ADDENDUM NO. 3, APRIL 30, 2009

RE: Ocean Avenue Elementary School
Portland, Maine
A/E Comm. No. 3316.10

FROM: WBRC Architects-Engineers
141 Preble Street
Portland, Maine 04101
Tel: (207) 828-4511

**N8 ALUMINUM GLAD WINDOW AT KITCHEN OFFICE 104C HEAD DETAIL**  
 3'-11\"/>

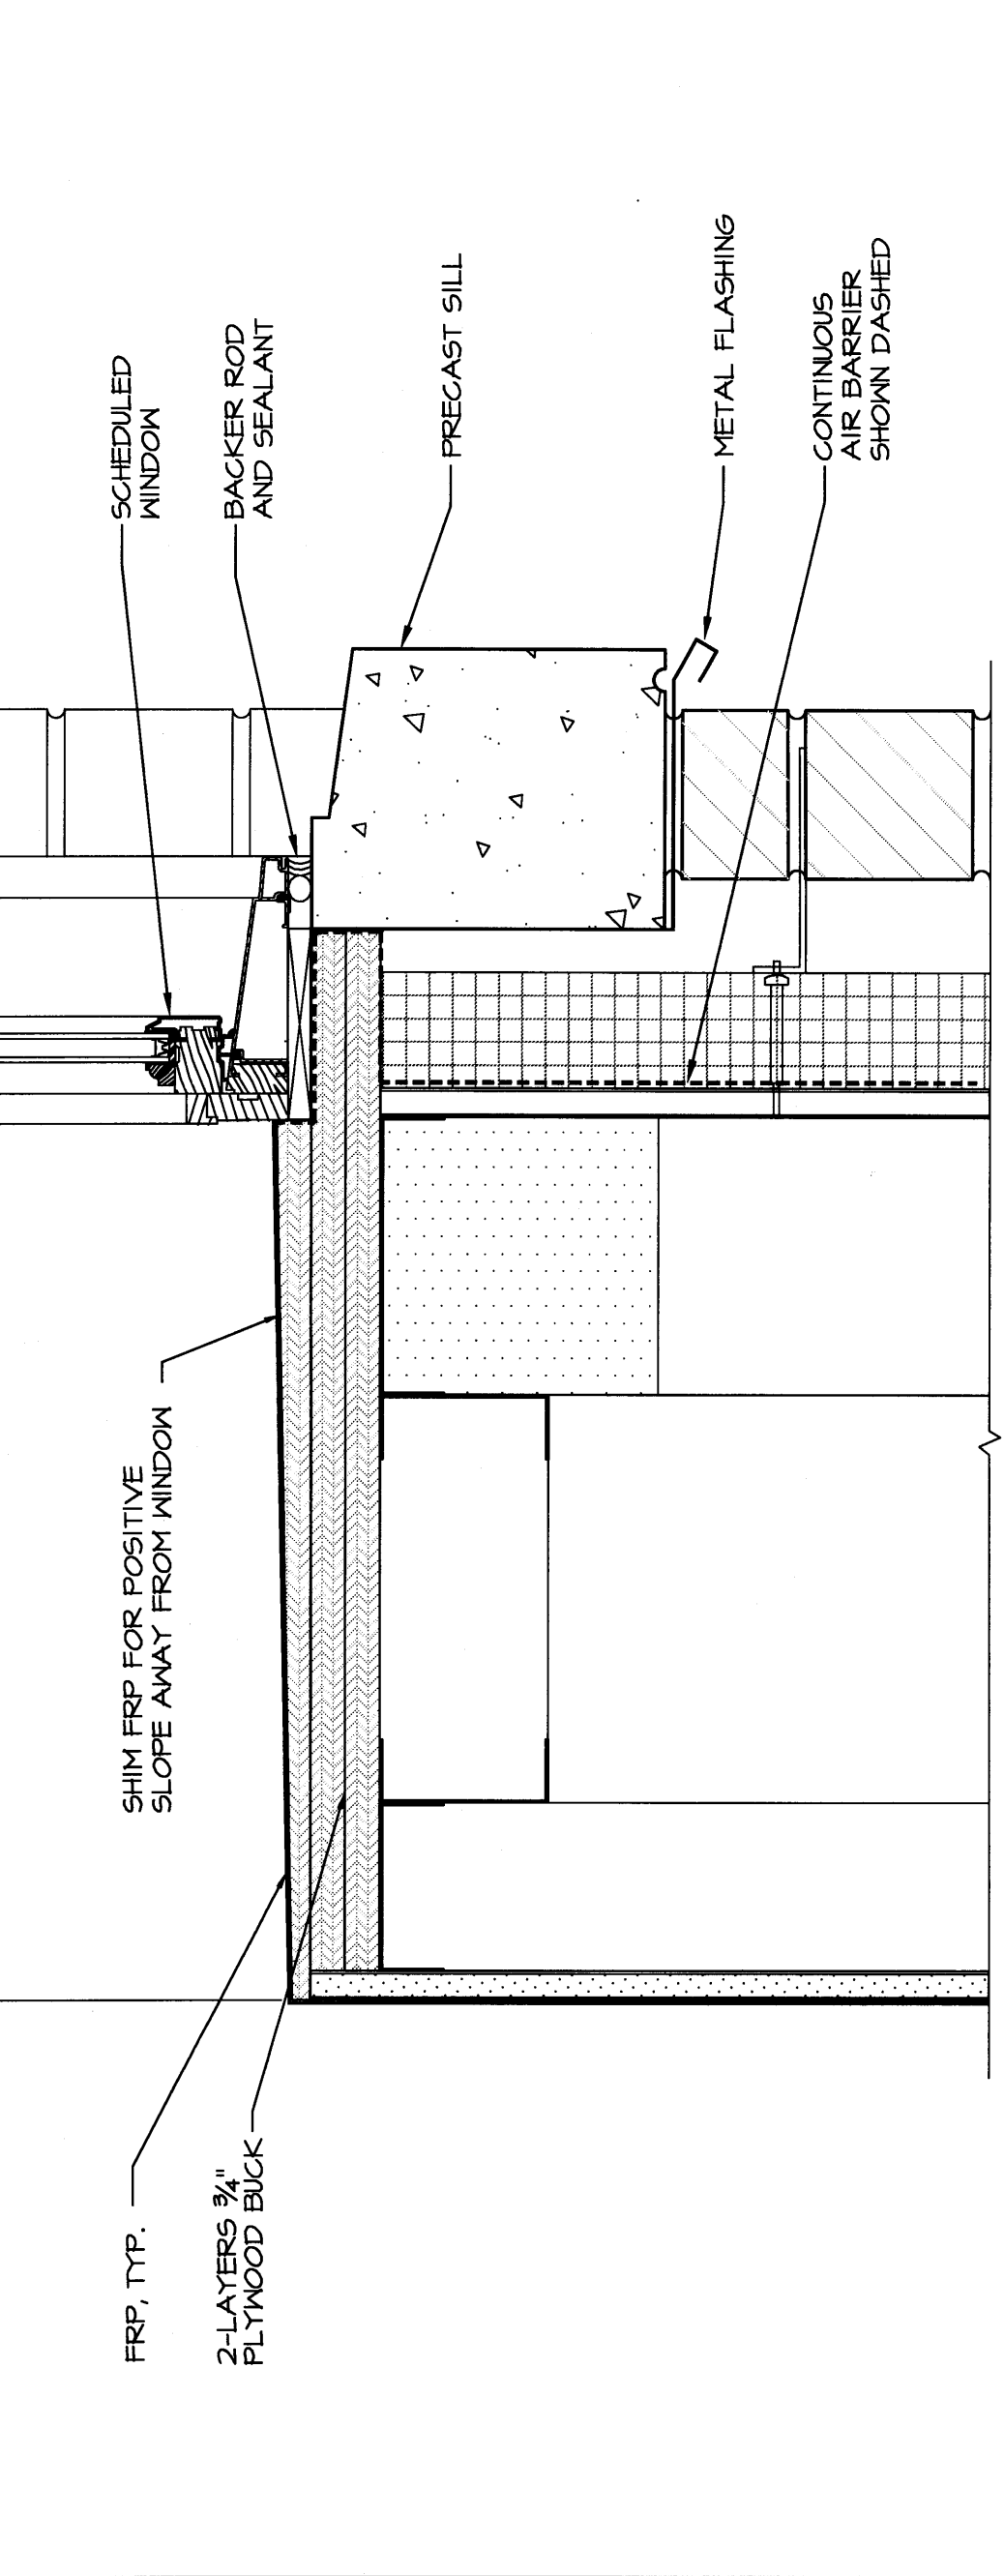
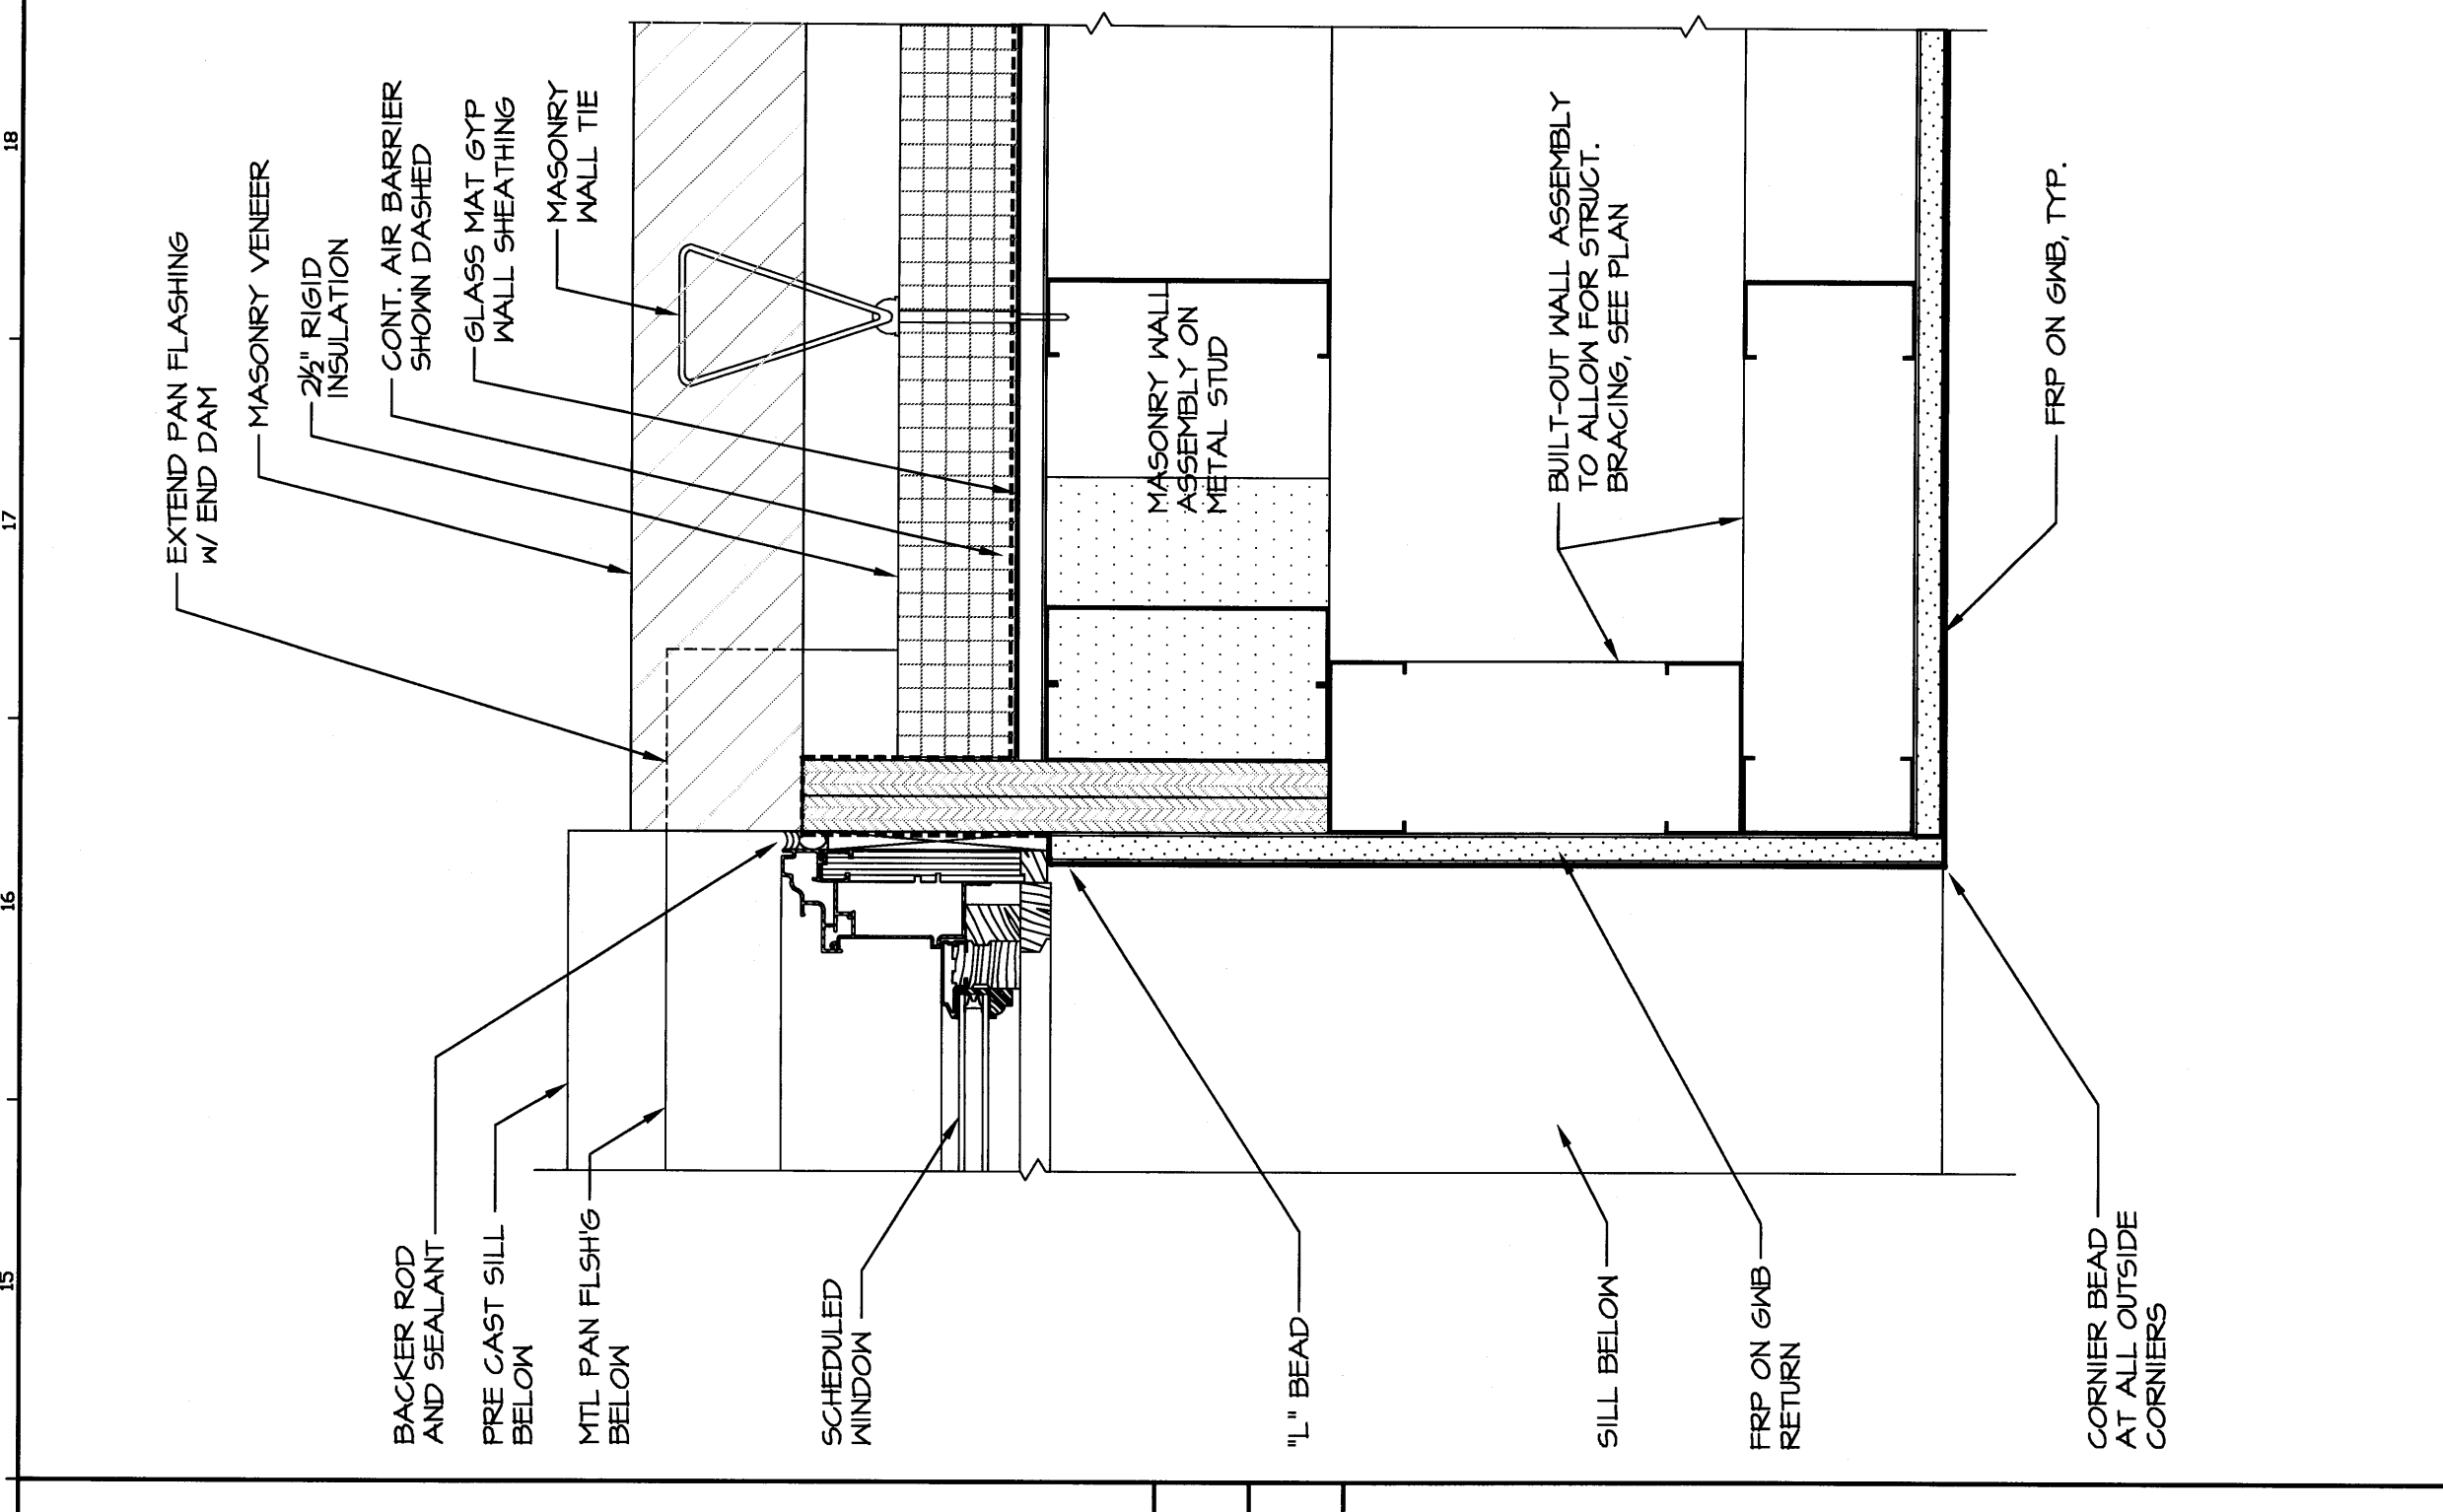
32. Sheet AE508, Window Details, REVISE portions as indicated on Sketch ADD3-AE508-1.
33. Sheet PL601, Plumbing Legend & Schedules, REVISE portions as indicated on Sketch ADD3-PL601-1.

**E11 LIGHT SHELF DETAIL**  
 11/2'-11\"/>

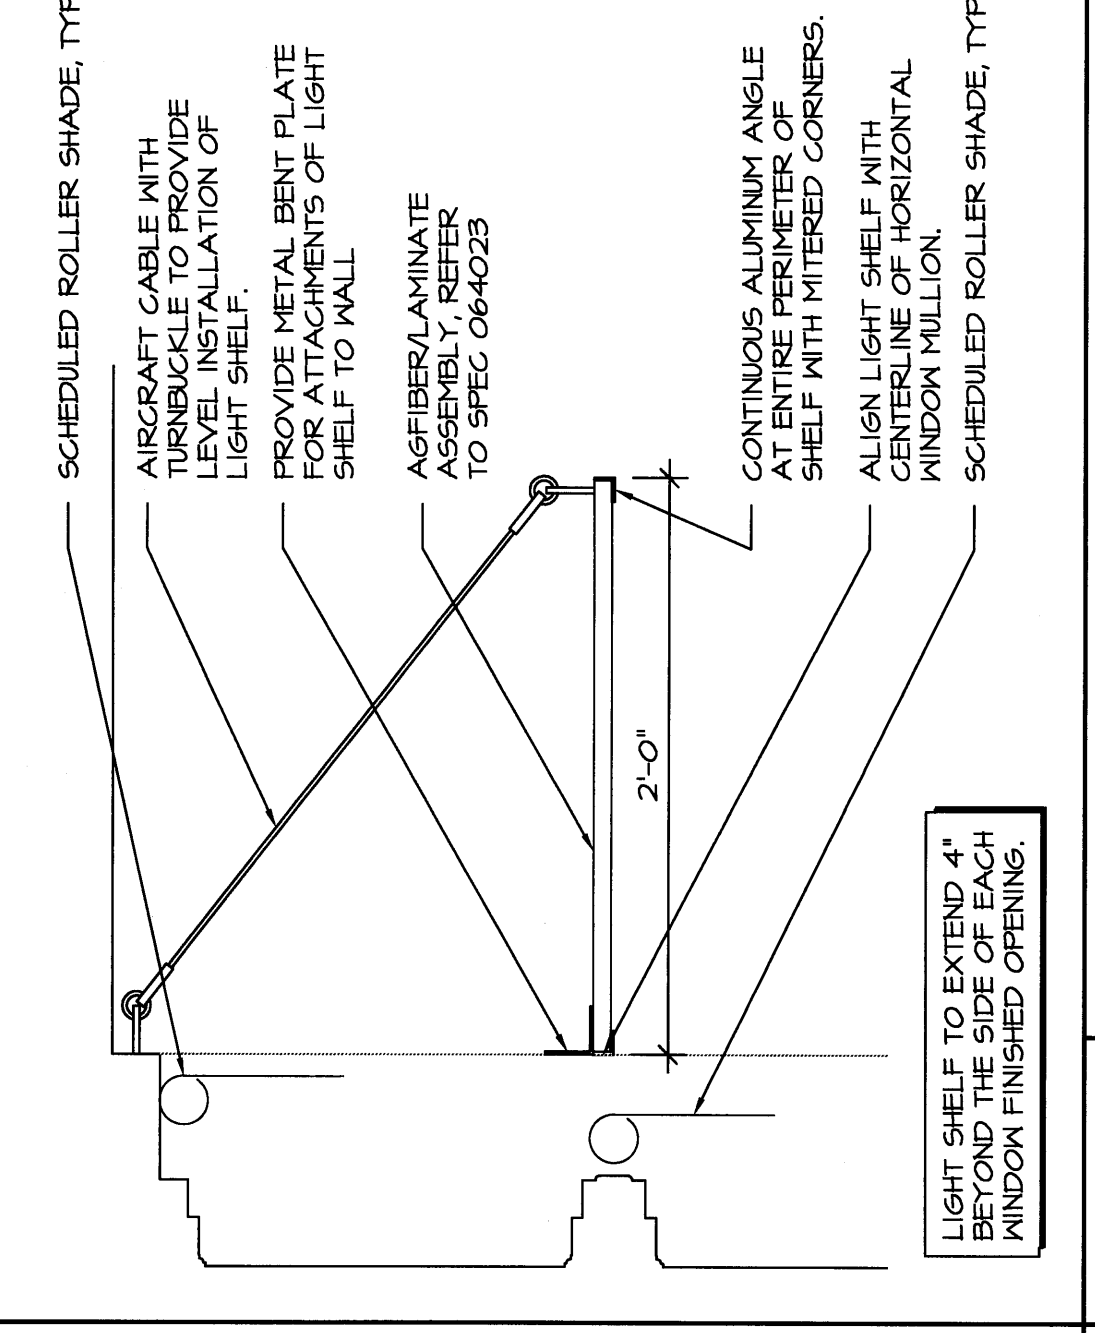
- 24. Sheet AE101-A, First Floor Plan Seg. A, Music #114, ADD Light Shelves at all exterior windows in Music 114 as per Detail E11-AE508.
- 25. Sheet AE102-C, Second Floor Plan Seg. C, REVISE portions as indicated on Sketch ADD3-AE102-C-1.
